**BUNTING MULTIFAMILY  
 SITE DEVELOPMENT PLAN**

**SITE PLAN**

**DP-2** MVE PROJECT 61072  
 MVE DRAWING -DEV-SP

DP-2 MVE PROJECT 61072
MVE DRAWING -DEV-SP

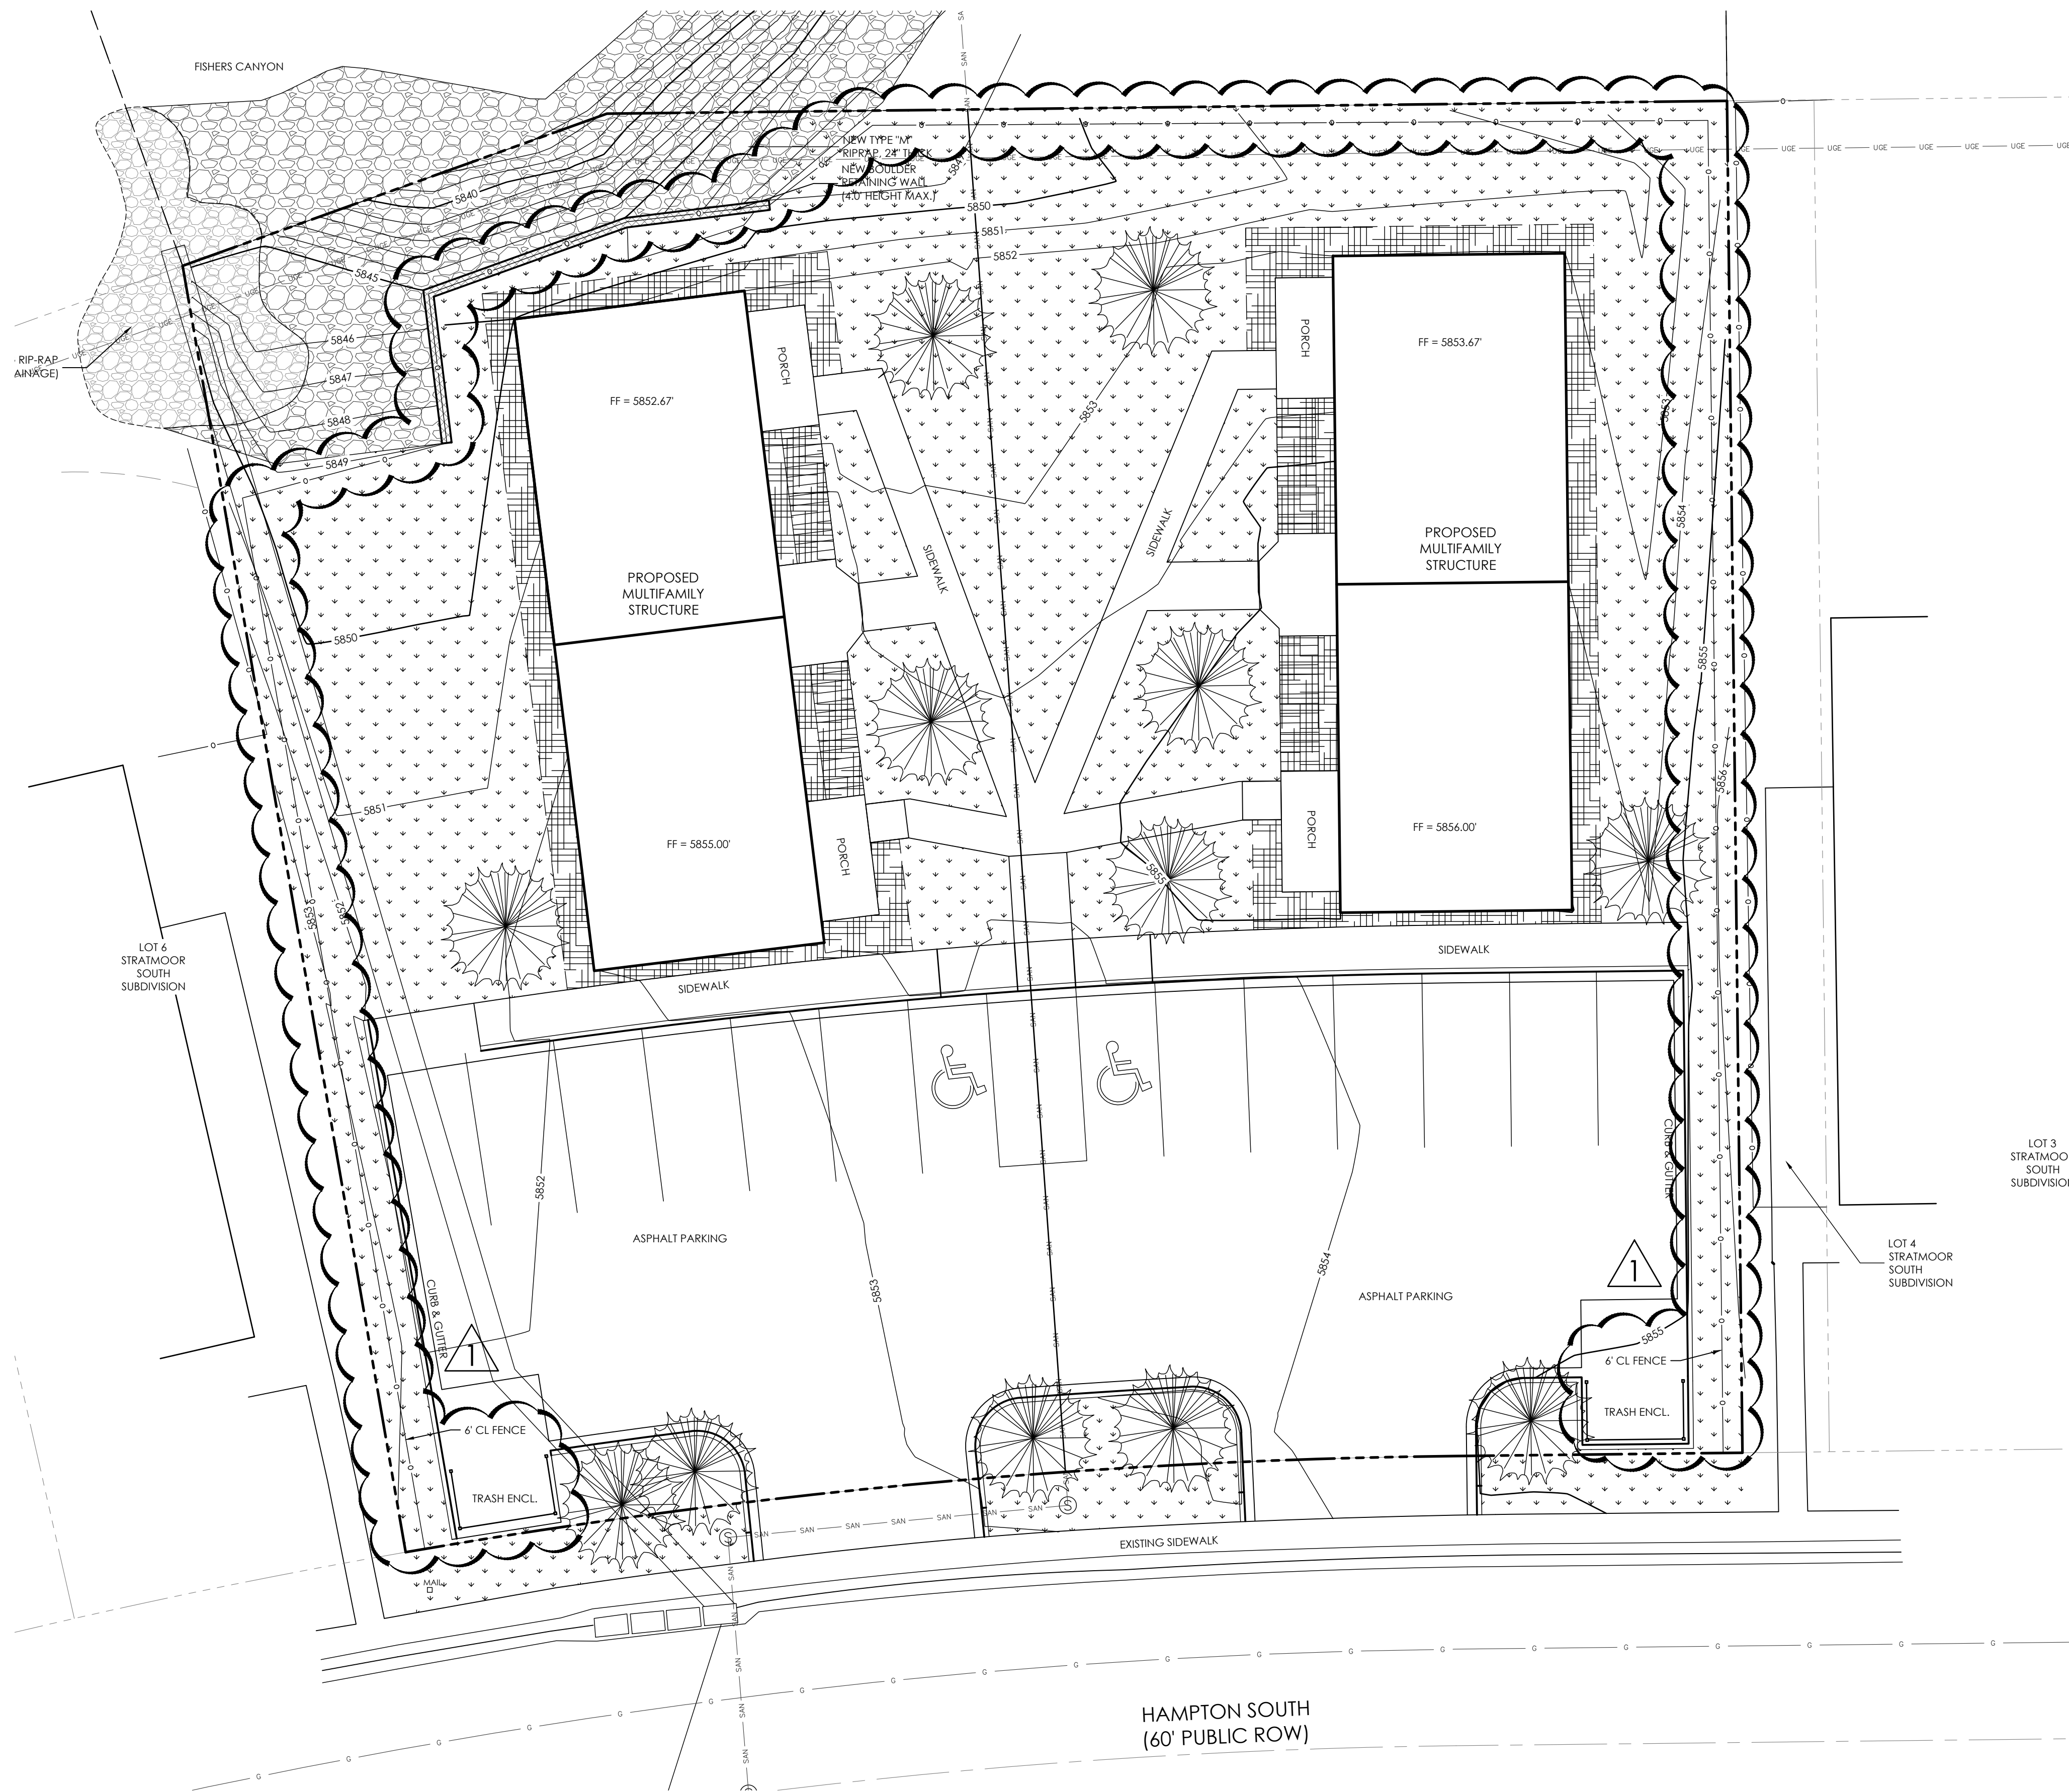
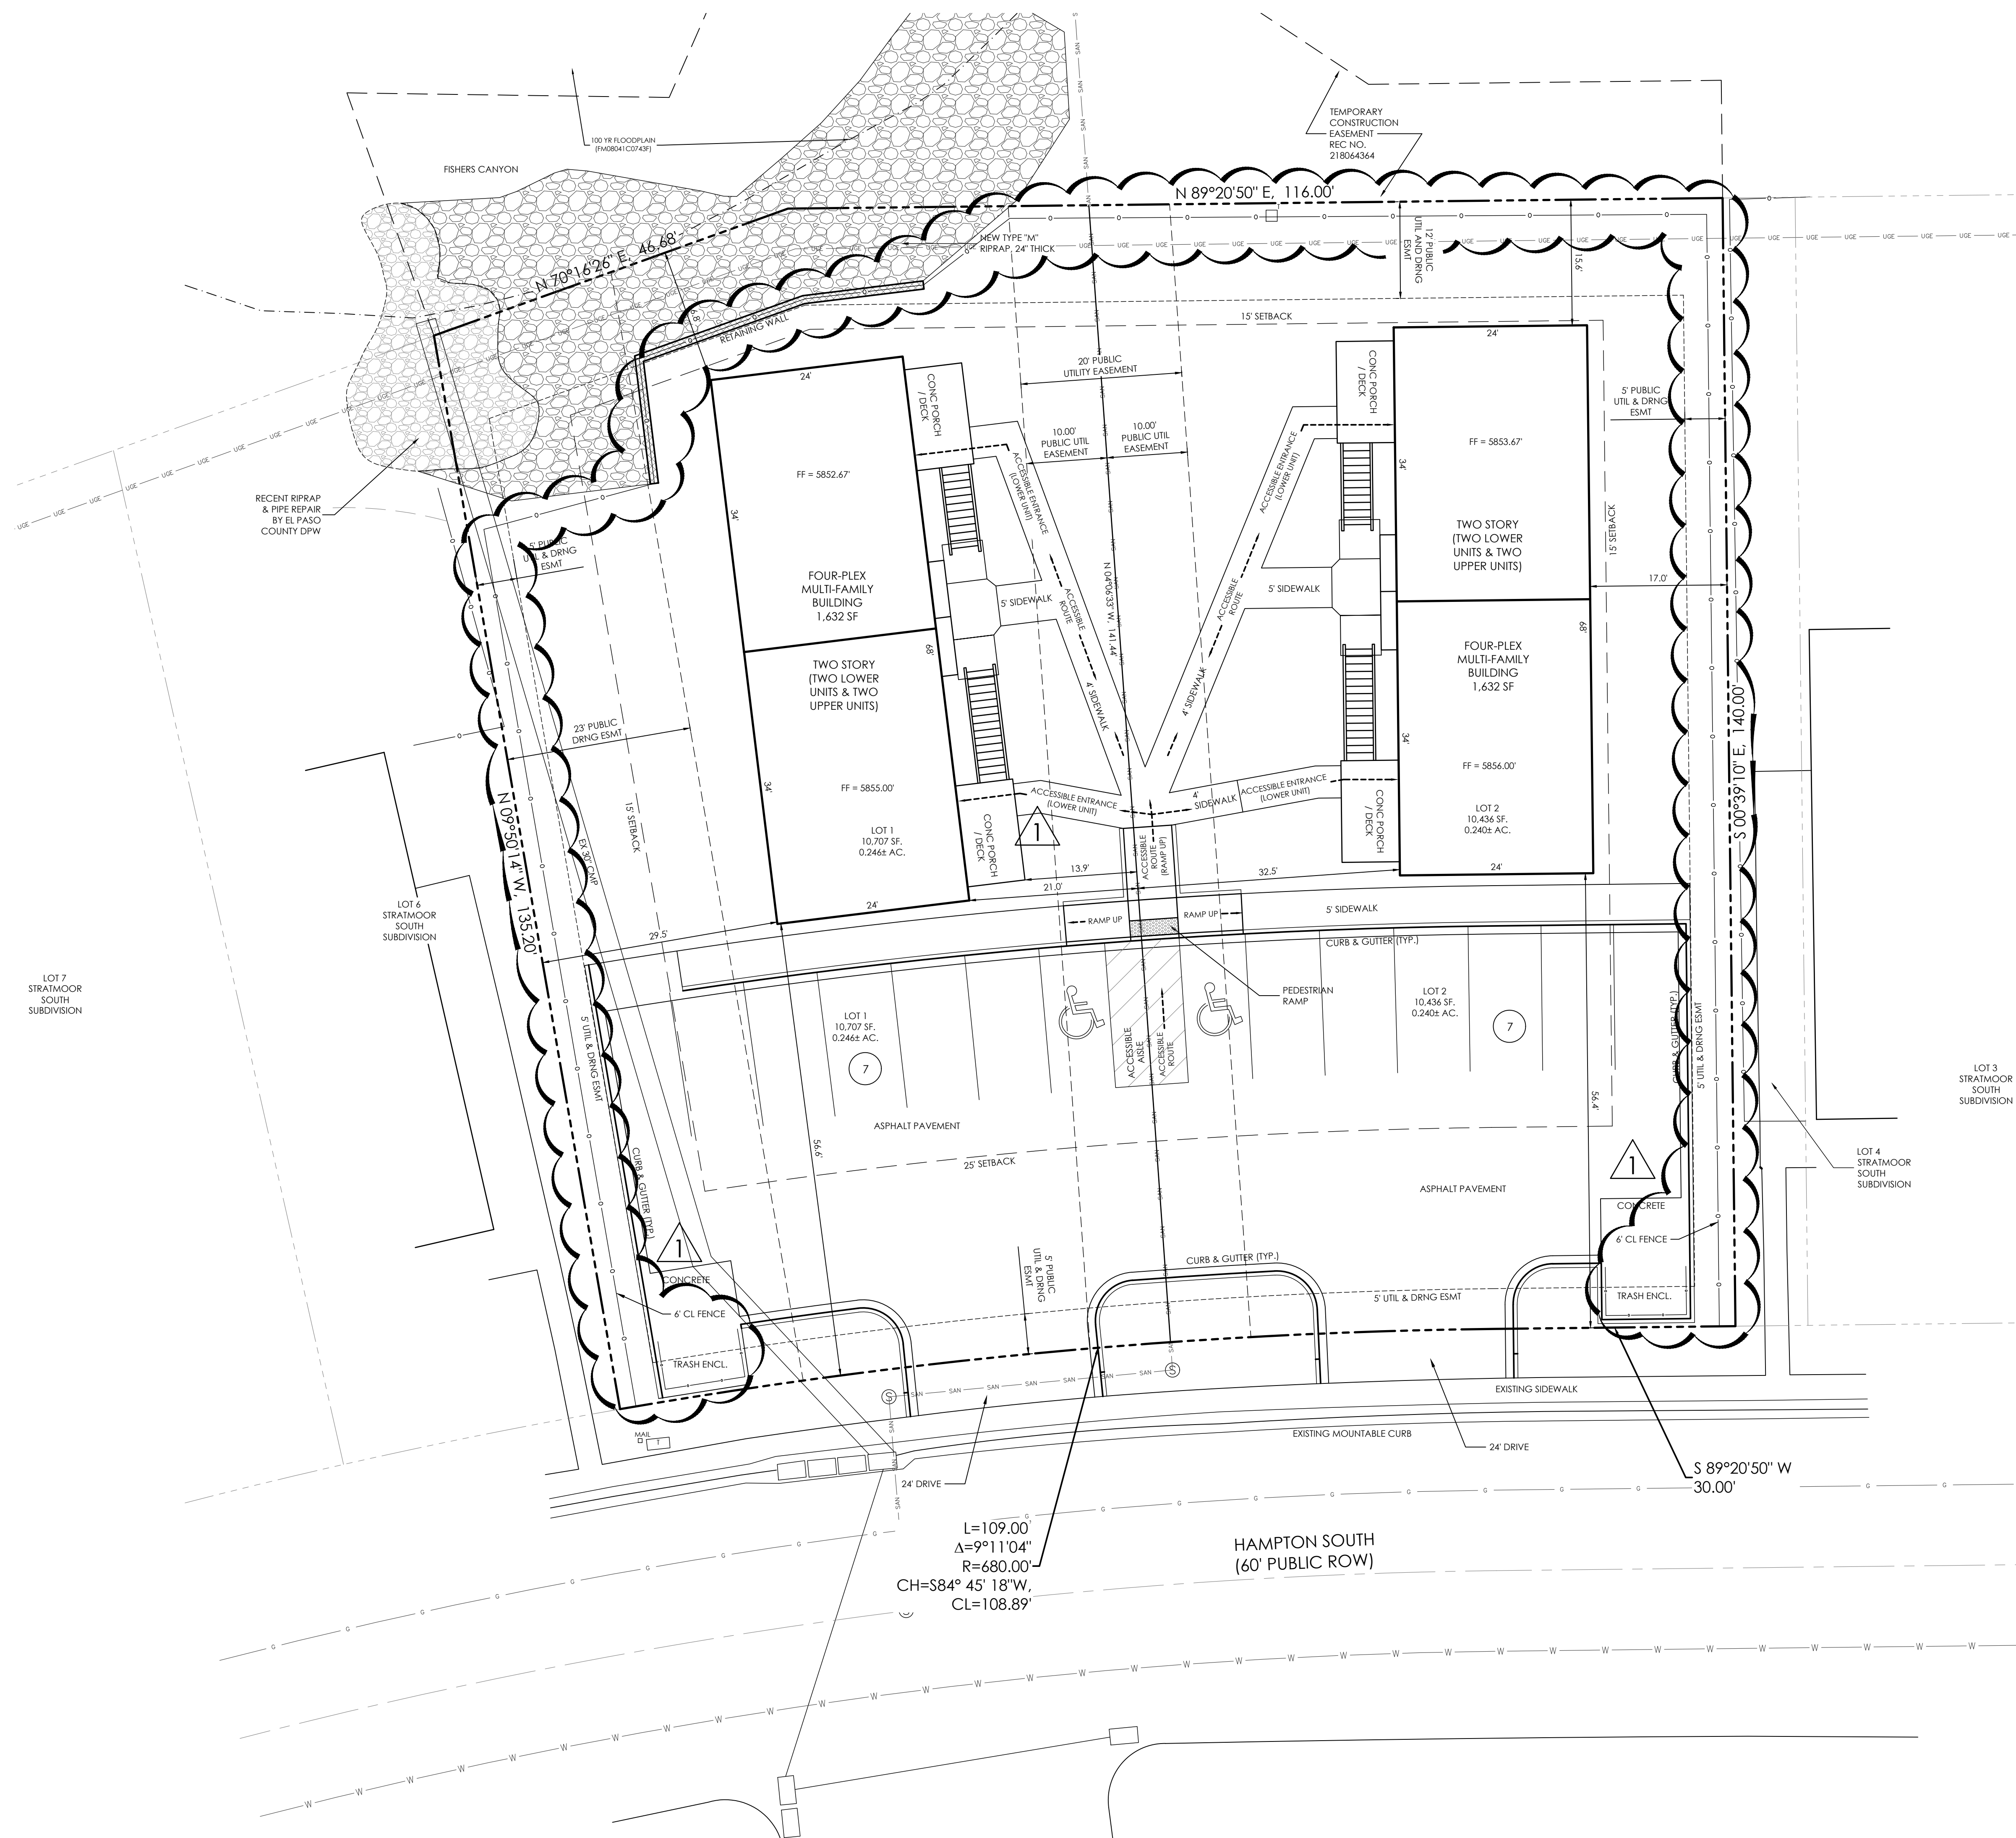
**Planning Comments, provided by Sophie Kiepe**  
 While the trash enclosure detail notes that there is fabric with vinyl privacy slats over the chain link metal, the detail itself does not show them and so the detail looks the same as the chain-link fence detail, which is not opaque. Preferably, please add a picture or other visual to show the vinyl slats proposed and demonstrating that it is to be opaque. Alternatively, then please add to this detail note something to expressly state that the privacy slats will make the fence opaque.

1. To be sure of the extents of the fence, please provide a legend for the fence linework. It would also help if this linework was larger or darker for visibility on the plan.
2. A drainage memo will be required to confirm that the fence will not impede the flow of water in the area where the fence crosses/is within a drainage easement.
3. In order to fully evaluate the request, the sight distance lines (per ECM chapter 2) should be shown on this plan to assure that the sight visibility is not hampered by the proposed fence and enclosure locations. A deviation from the ECM for the sight visibility is not acceptable.
4. Please provide the ground location on the details to confirm the actual height of the fence that will be above ground.
